From: **Ivan Wilson** <[ivan@iwarchitects.co.uk](mailto:ivan@iwarchitects.co.uk)>  
Date: 12 May 2015 at 12:57  
Subject: Re Mill Hey Croft, Chatburn. Proposed extension.  
To: Adam Birkett <[Adam.Birkett@ribblevalley.gov.uk](mailto:Adam.Birkett@ribblevalley.gov.uk)>

Proposed Elevations

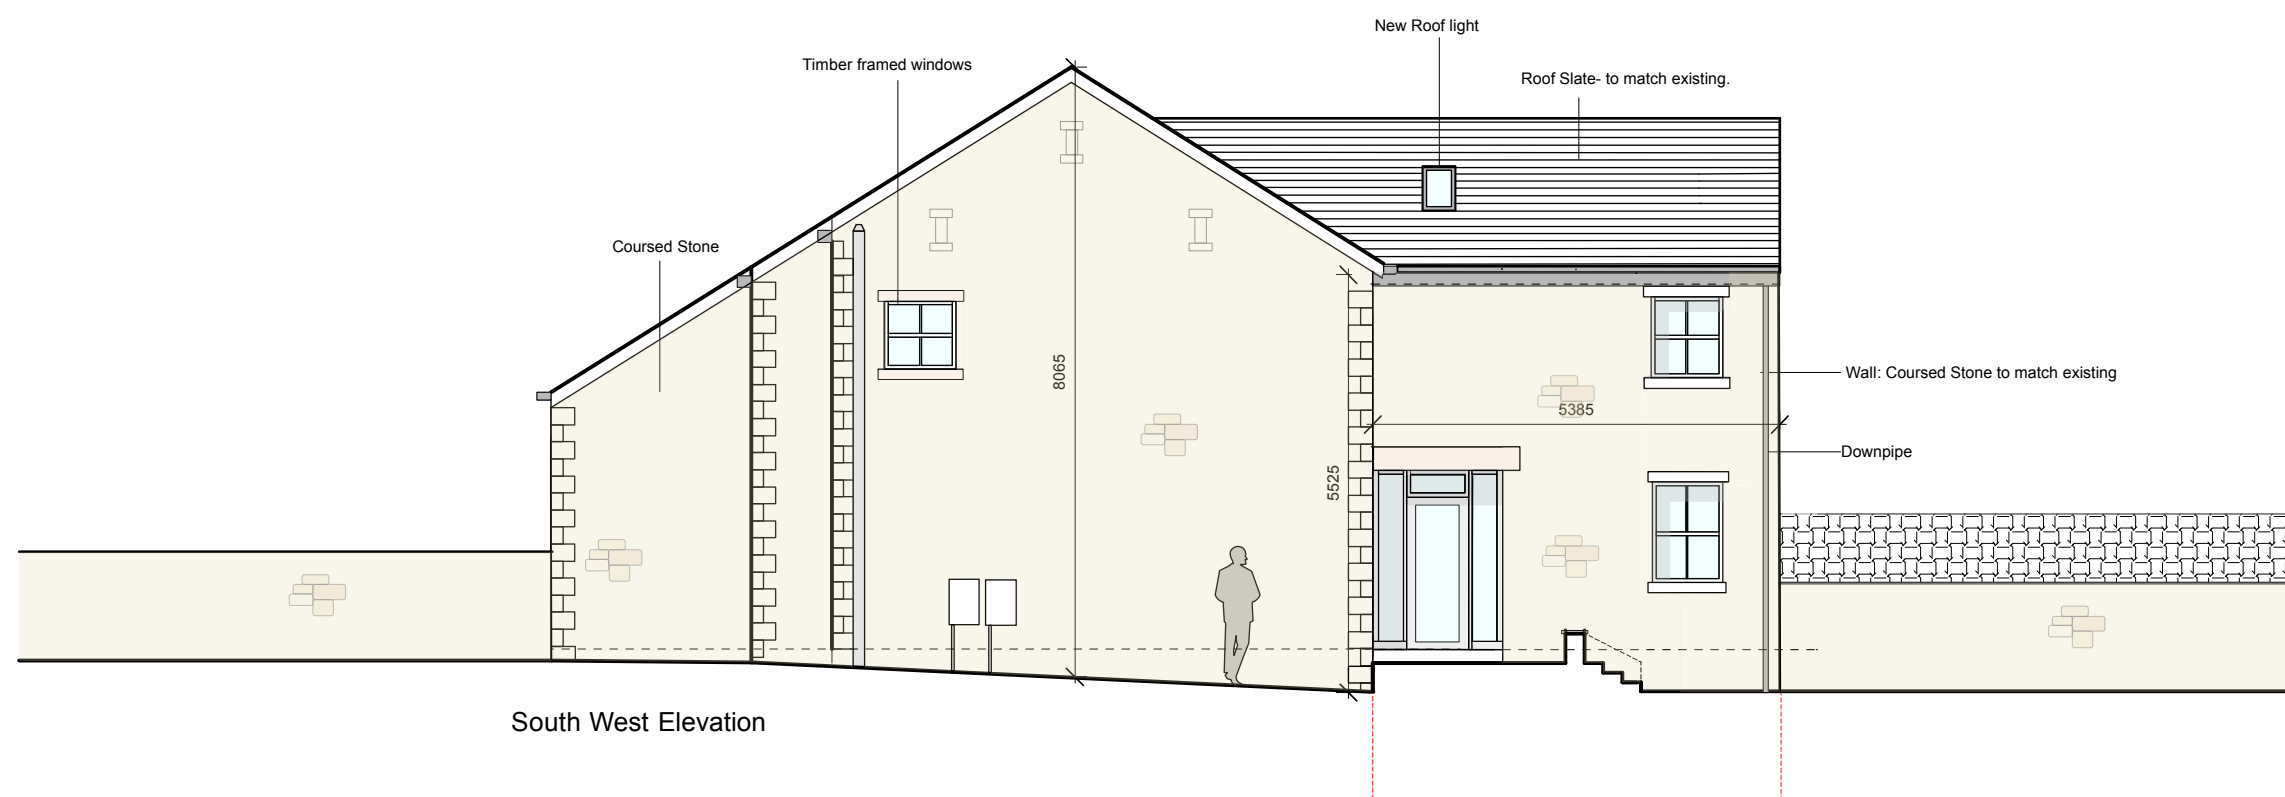
1. Your request to reduce the size of the new bedroom window in the existing gable from a double to a single width.  
The client wishes to offer a compromise as this is the main bedroom window: by reducing the height of the window heads making the window height 900mm (with a 900mm cill height) matching the other existing windows, but keep the double window width.

2. Your request to reduce the size of the extension gable glazing: the client has sent the attached photos of the adjacent barn conversion are helpful in that it has similar full height glazing. Again I suggest a compromise of say approx. 2.4 metre wide glazing (retained as full height) in three panes with stone facing to the rest of the wall either side. (see attached revised drawings)

4. Omission of the timber cladding and having the walls stone faced is agreed for the extension gable. 4. The request for traditional pattern of windows facing the church yard has also been accepted and shown.

Proposed GF Plan

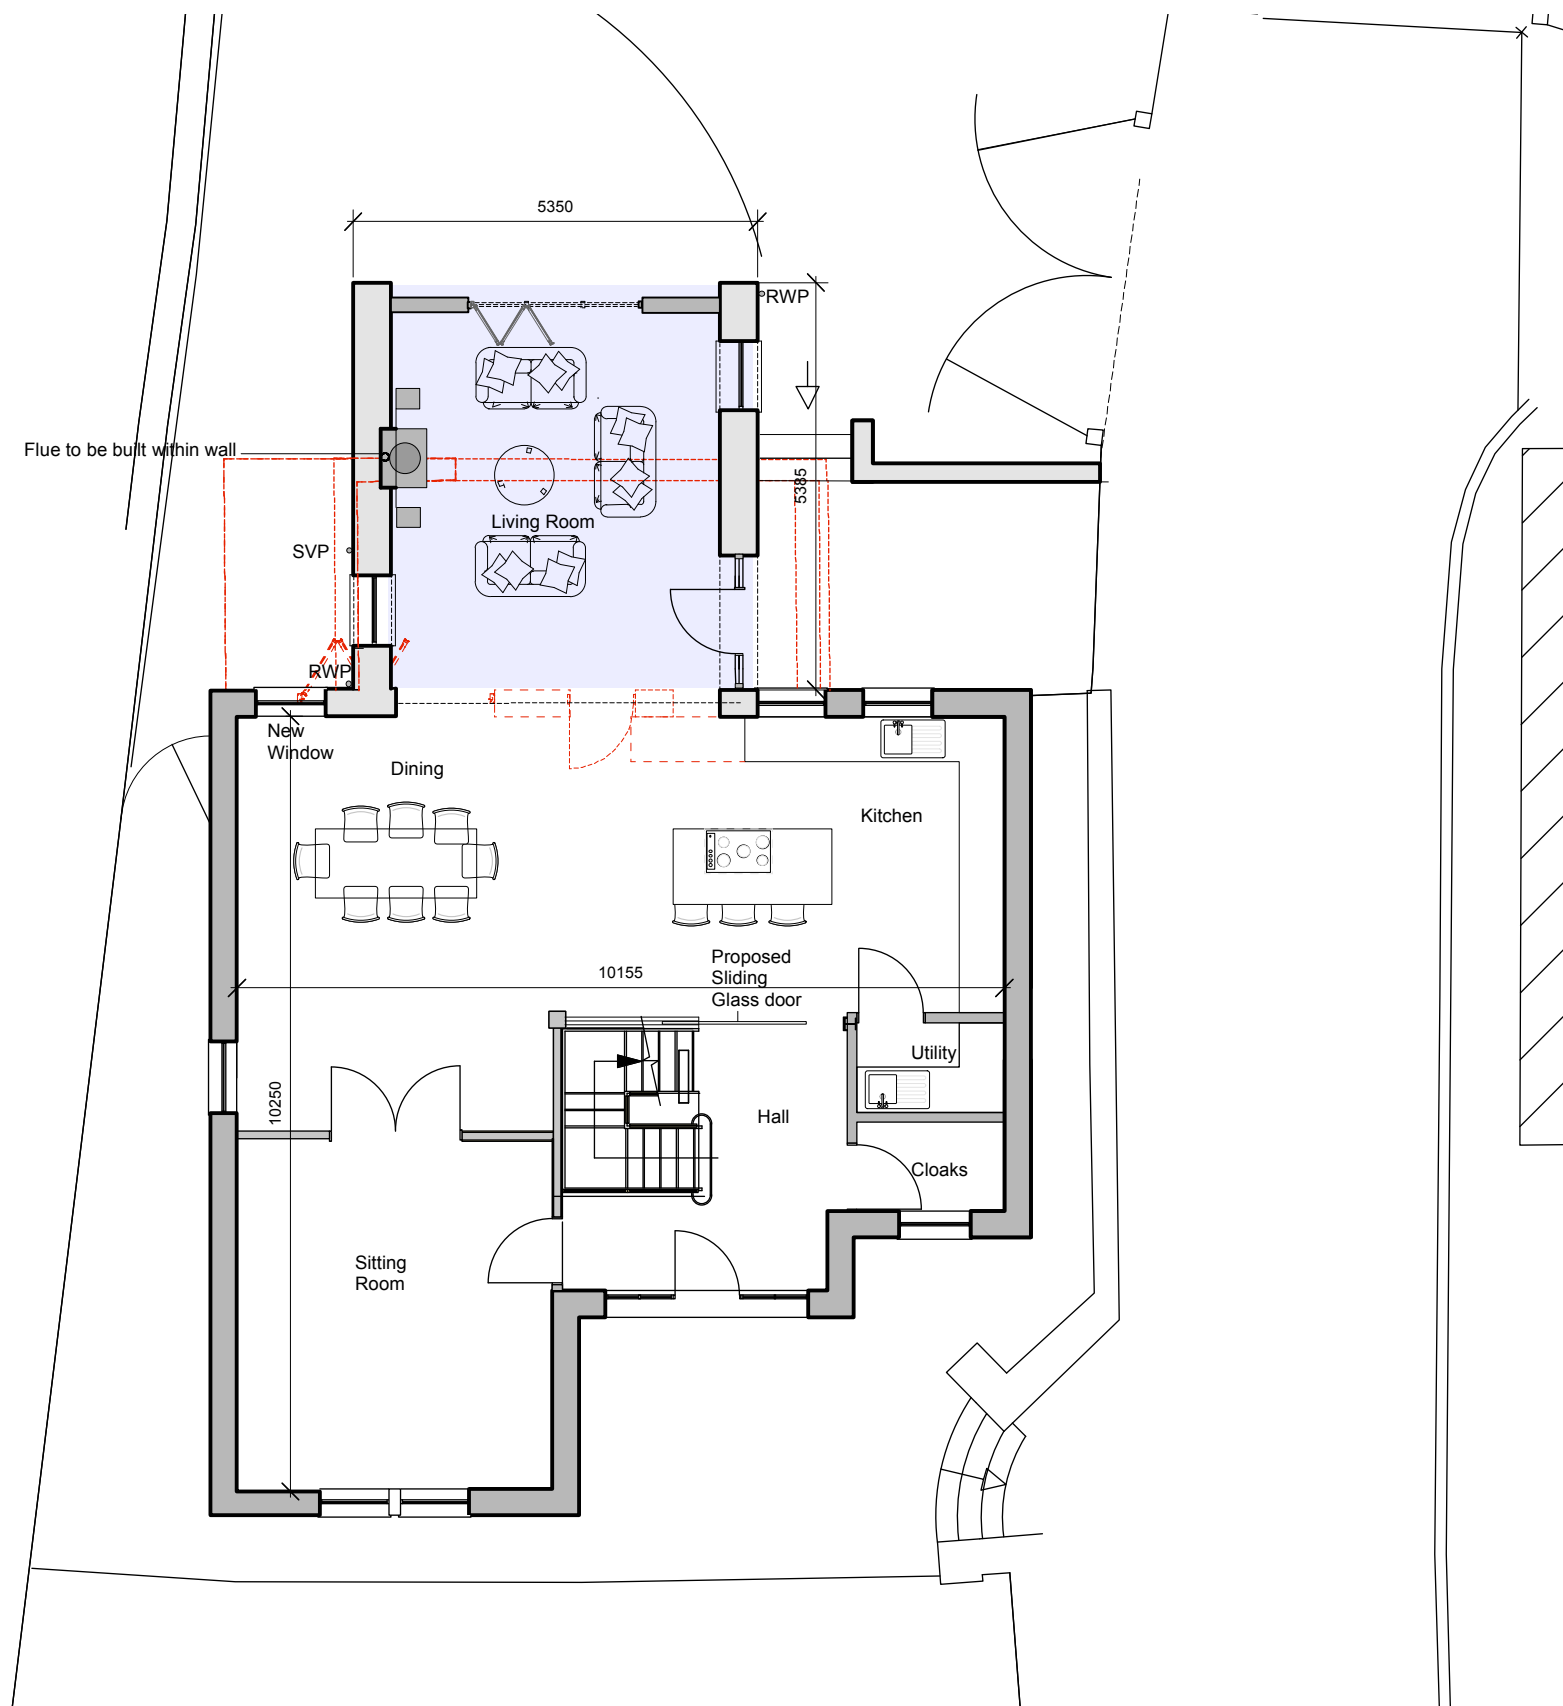
3. Your request to reduce the size of the extension from 6 metres to 3.5 metres;  
The client thought this to be an unreasonable request especially so as it had not been raised initially. It seems unreasonable largely because it would make it impossible to provide the required accommodation. It is not possible to provide a reasonable / normal sized double bedroom and ensuite with a 3.5 metre extension. The clients will soon be a family of 5 with twins expected at present and the accommodation indicated will be needed. They are also changing their longer term plans to move as Damien has changed his job and is now a coach at Blackburn Rovers. So this house will be their home for the foreseeable future.  
The only possible compromise whilst retaining reasonable room sizes would be to offer the centralised extension shown with a reduced projection of 5.5 metres externally instead of 6 metres. This still provides the accommodation required with only minor reduction and changes internally. The central extension also has the advantage of having less visual impact due to its location. It will not be possible to see it from the public road side (south and east side) of the church and house nor from the public side of the churchyard. It will also have a much reduced visual presence from the north side of the churchyard as it is further away from the churchyard and the wall and levels help.
